**KIRKLEES METROPOLITAN COUNCIL
INVESTMENT & REGENERATION SERVICE**

DELEGATED DECISION TO DETERMINE PLANNING APPLICATIONS

Reference No:	2025/62/90922/E
Site Address:	Newgate Garage, Newgate, Mirfield, WF14 8DB
Description:	Erection of outbuilding, extension of existing garage and associated alterations
Recommending Officer:	Nina Sayers

DECISION - REFUSE

PROJECT TITLE NEWGATE GARAGE			
DRAWING TITLE BLOCK PLAN			
SCALE 1:500	DRAWN EC	CHECKED JH	PROJECT REFERENCE ODS_21-499
PAPER SIZE A3	DWG NUMBER (20)002	DATE 27/02/24	REVISION 1
CLIENT MOHAMED ADEEL

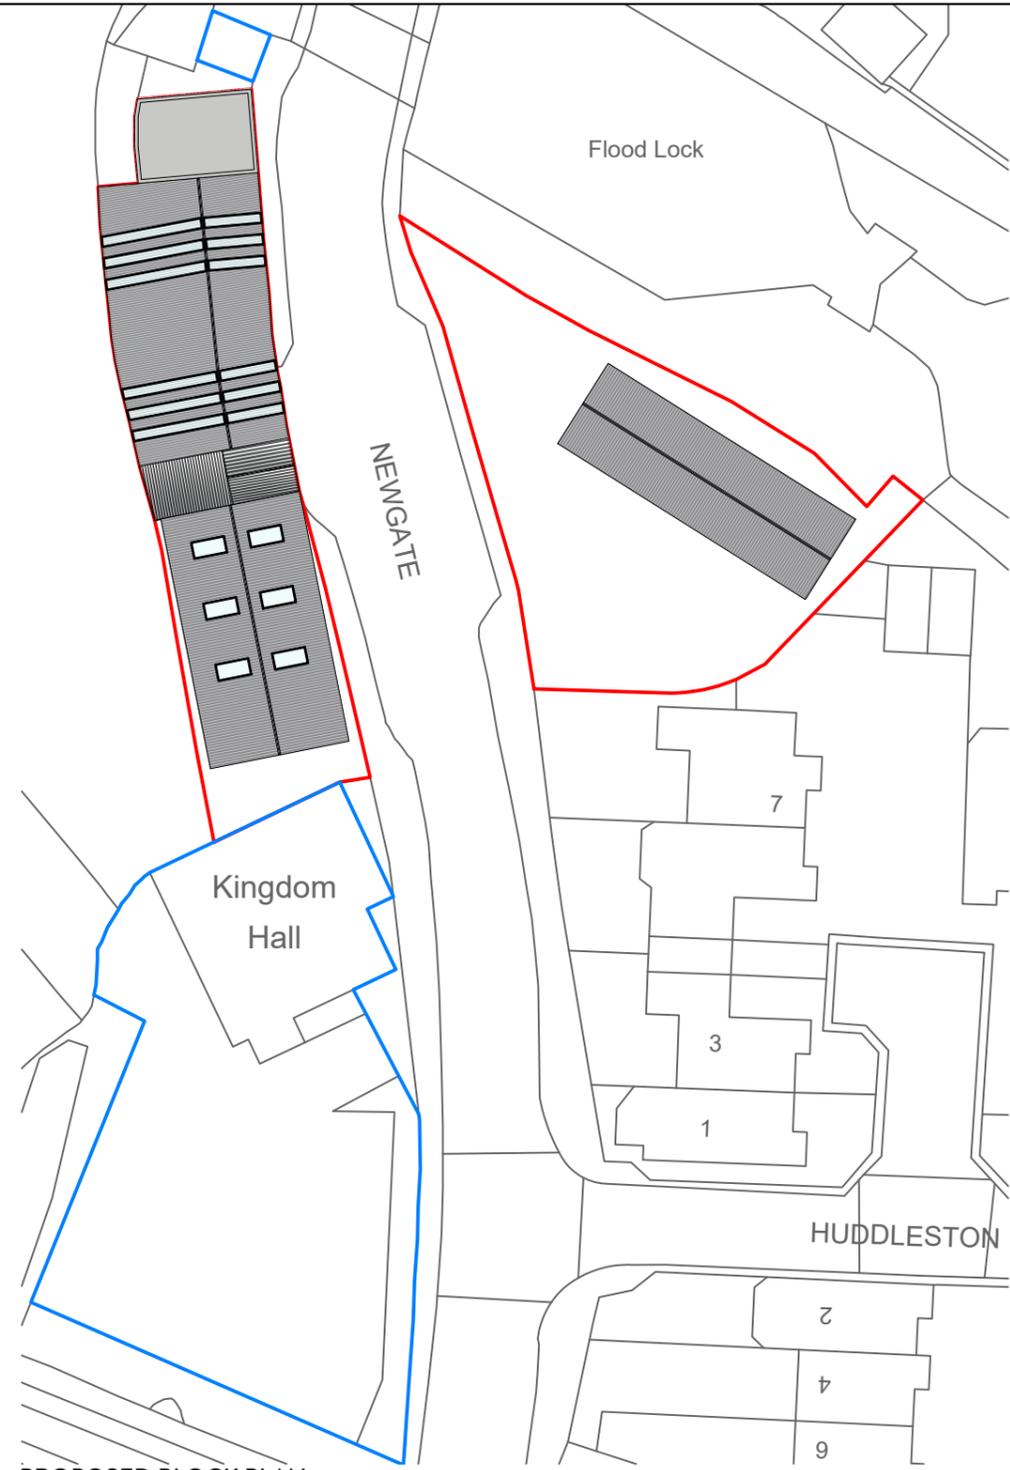
Officers have significant concerns that the scale of the proposed outbuilding, as well as the materials, would neither preserve nor enhance the significance of the heritage asset, thus failing to comply with LP35 of the Kirklees Local Plan and Chapter 16 of the NPPF.

- the extension and the proposed new building would result in the loss of off-street parking provisions for the garage.
- The proposal also shows three new service bays with direct access onto Newgate however there is no provision for internal vehicle turning.
- The Sight lines onto Newgate from all three service bays would be sub-standard in both directions.
- Inter-visibility between vehicles exiting the service bays and pedestrian using the Newgate footpath would also be poor.

Given the Highway Safety Section comments and the record of complaints regarding on-street parking along Newgate, and that these proposal would result in a loss of off-street parking facilities, access to the service bays is directly onto Newgate with no internal vehicle turning and with poor sight lines and poor pedestrian inter-visibility Highways Development Management have recommended refusal of these proposals on highway safety grounds.

FRONT ELEVATION
1:100

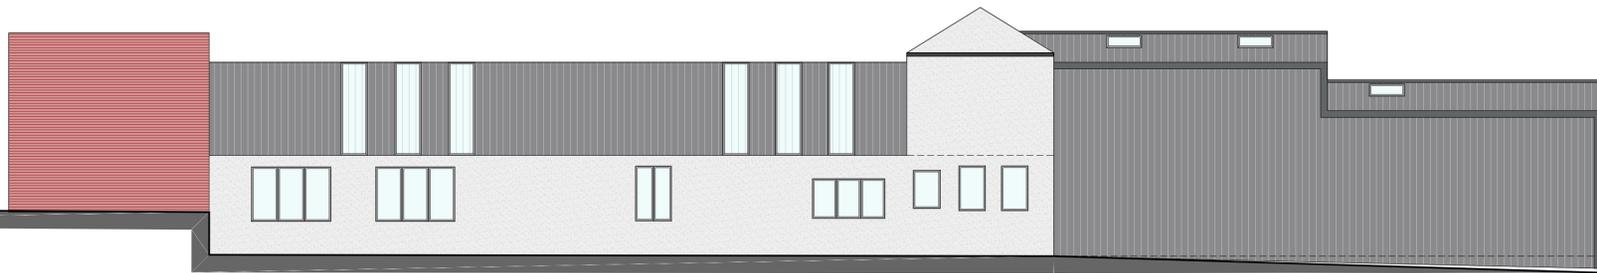
The proposed extension would be large in scale and officers initially had concerns regarding the proposed height and roof design in relation to the existing building. Amended plans were received which adjoin the existing roof and staggers the roof height to reduce the height. Whilst ideally officers would prefer the roof height to mirror the existing pitched roofed section, Officers understand that the roof height is required to allow for vehicle inspection of a van and therefore the proposed roof height is considered acceptable on

The proposed change in materials changes the entire building (as well as the proposed extension) to be finished in grey corrugated metal cladding. It is noted that this is retrospective, and the building was previously finished in brick and white render walls under corrugated steel roofing. The existing buildings in the surrounding area are finished in red brick and stone which is characteristic of the area. The proposed change in materials is considered to not be in keeping with the existing development and therefore cannot be supported.

1. The proposed aluminium cladding on the exterior walling of the existing and proposed buildings and extension would not be in keeping with the existing material palette within the wider street scene nor would it be in keeping with the original building's materials of construction. Similarly, the scale of the proposed outbuilding would fail to sympathetically integrate into the historic setting of the site. The proposal would therefore cause significant harm to the visual amenity of the existing building, wider street scene and would neither preserve nor enhance the setting of the Grade II listed Canal Lock, thus failing to comply with LP24 and LP35 of the Kirklees Local Plan and Chapter 12 and 16 of the National Planning Policy Framework.
